The Planning Inspectorate

Our Ref: EN010143

Application by East Yorkshire Solar Farm Limited for an Order Granting Development Consent for the East Yorkshire Solar Farm

Advice following issue of decision to accept the application for examination

Drawing Title  
**LAND PLAN SHEET 9 OF 22**

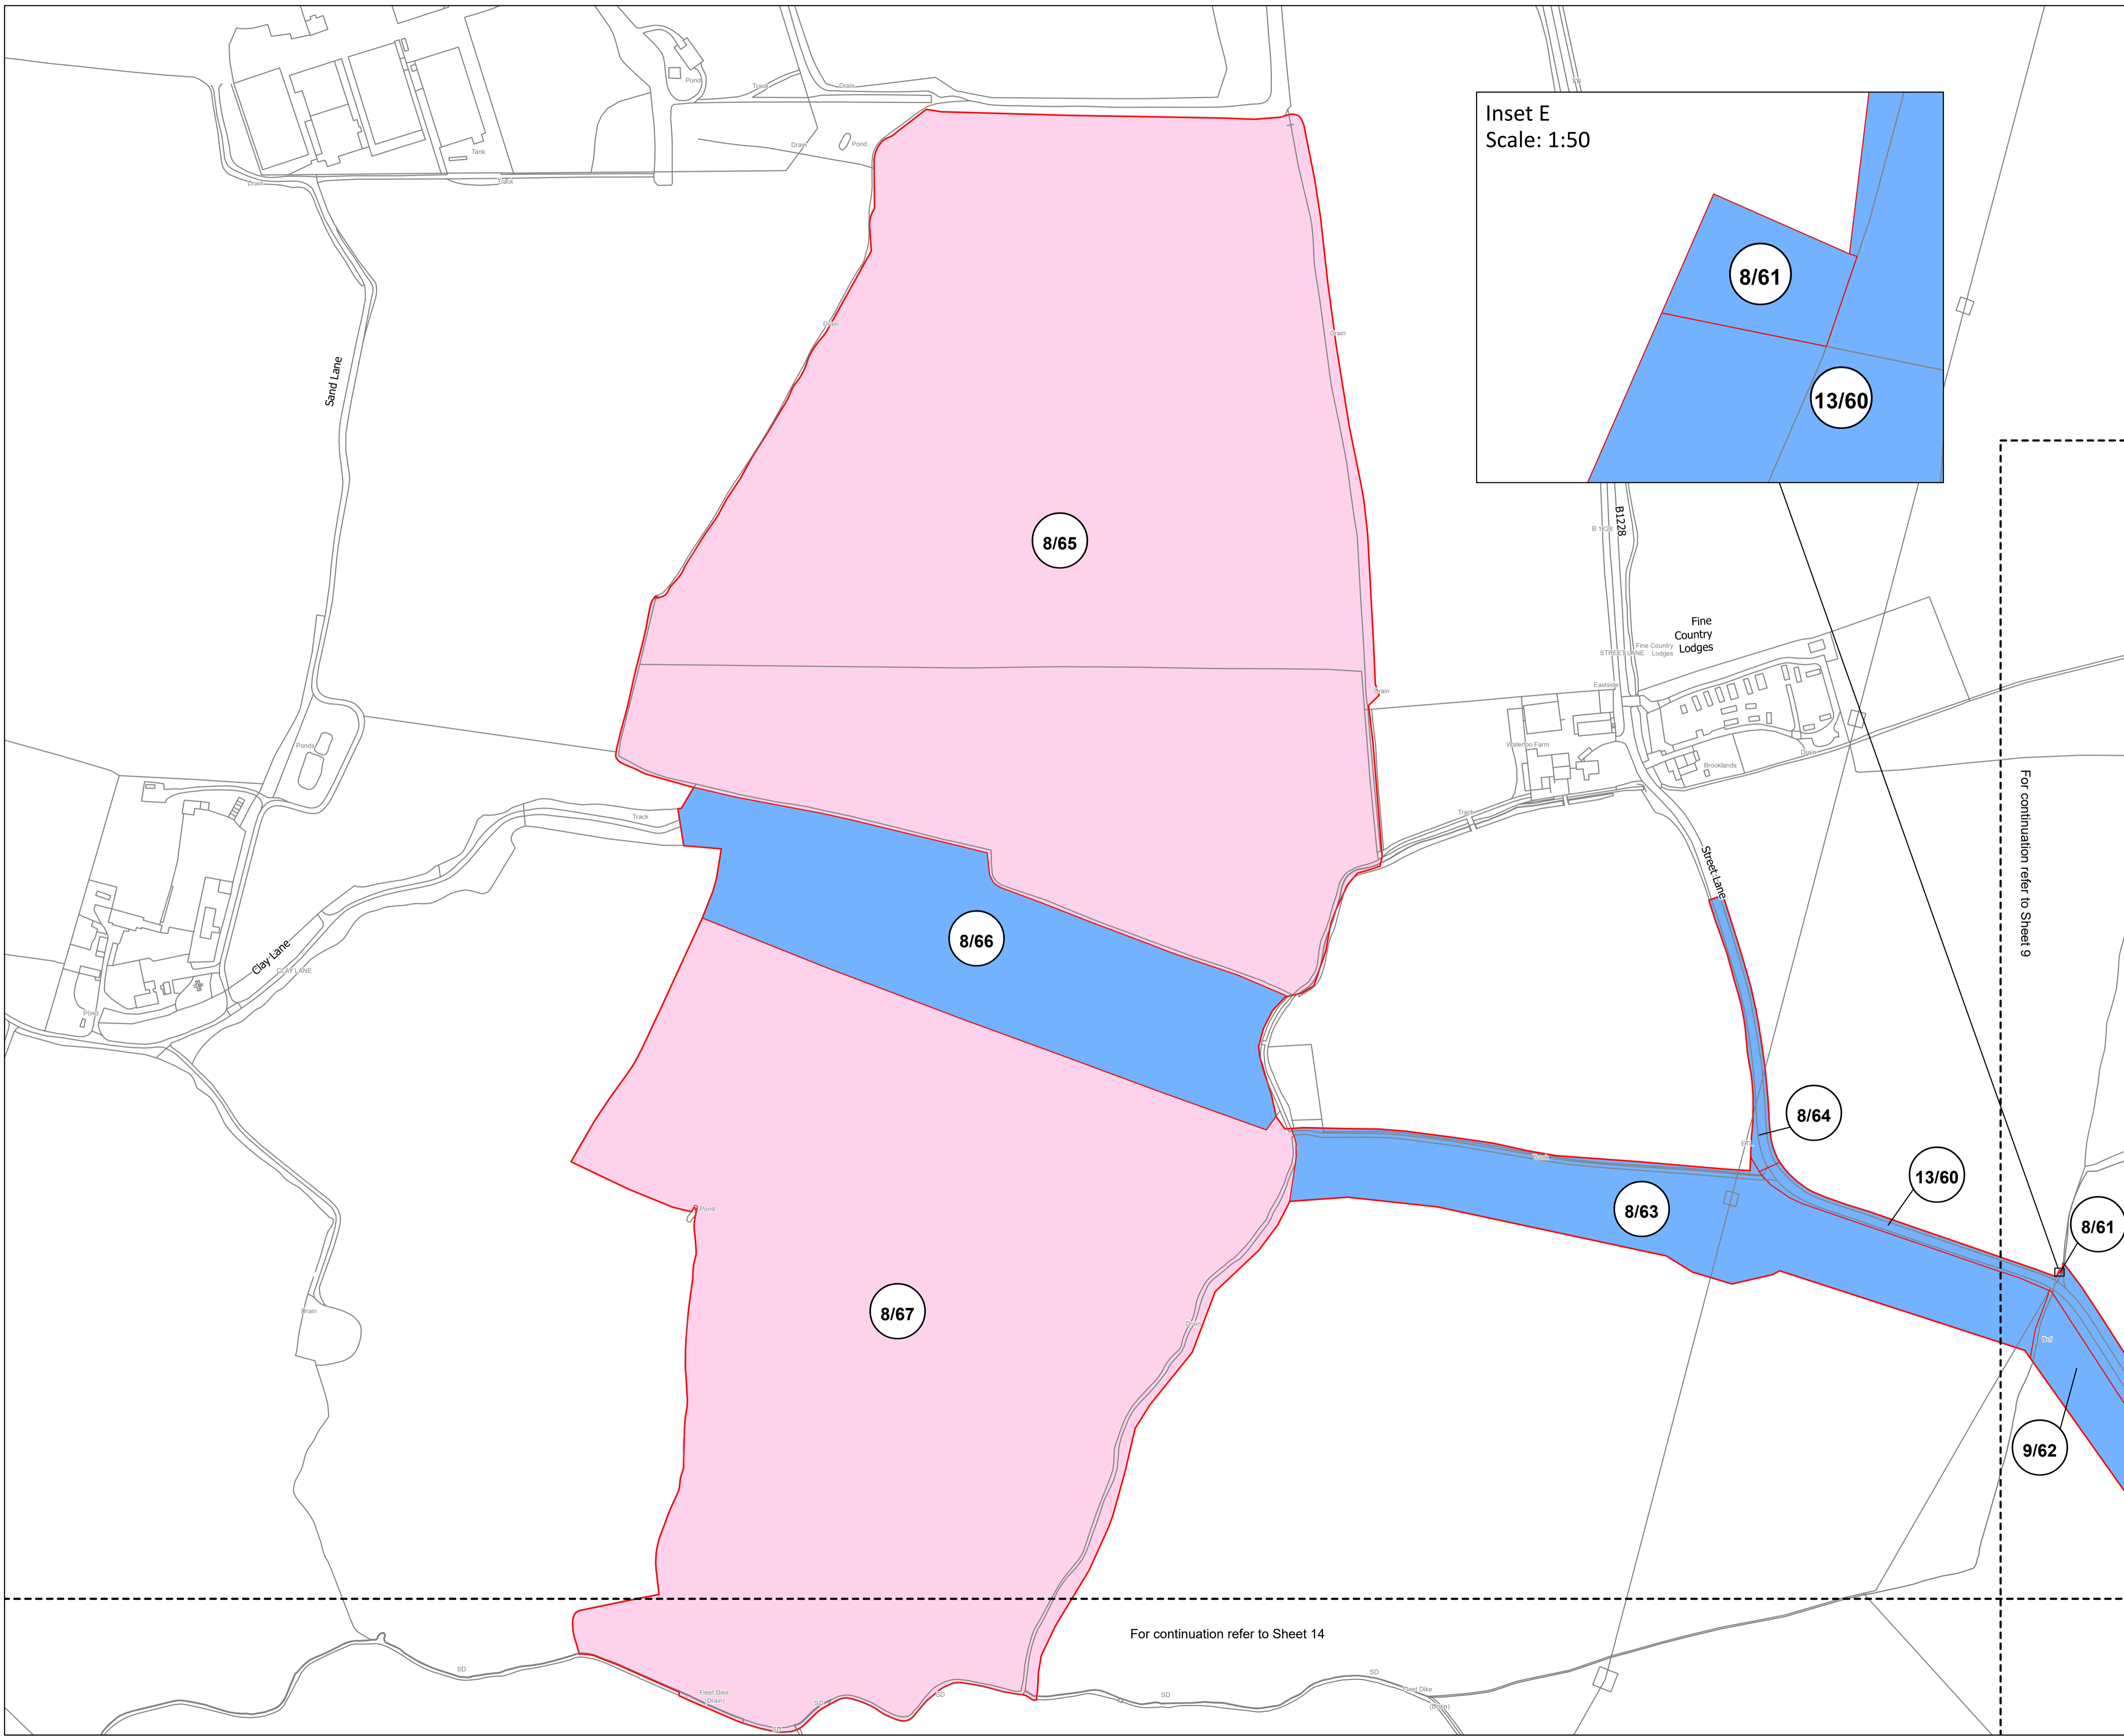
An inconsistency has been identified for Plot 9/58 between Parts 2 and 3 of the BoR, when compared to the Land Plan (**Doc EN010143/APP/2.1**) and **Table 1** of the Schedule of Negotiations and Powers Sought (**Doc EN010143/APP/4.4**). Whilst this plot is described as permanent acquisition of new rights in Parts 2 and 3 of the BoR, the Land Plan and

Table 1 of the Schedule of Negotiations and powers Sought, describes the plot as being subject to temporary possession in Part 1.
